MEMORANDUM

To: FILE
From: Nell Donaldson
Subject: Application ID: 2014-220
Date: 3/19/2015

Re: Review Comments for 1210 Brighton Ave – Portland Hotels

6 RIPRAP SWALE DETAIL
C4.5 NOT TO SCALE

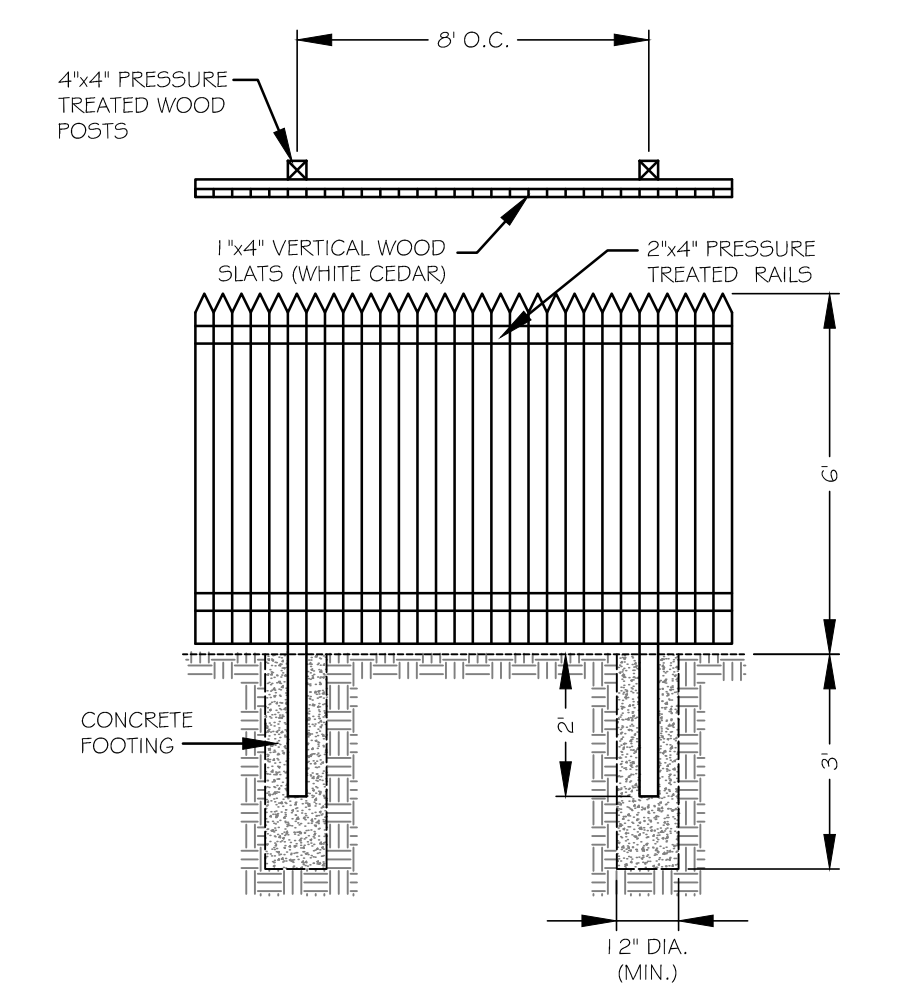
1. The applicant shall supply an easement for the rip-rap swale areas on City property discharging stormwater across the exiating Portland Pipeline easement area.
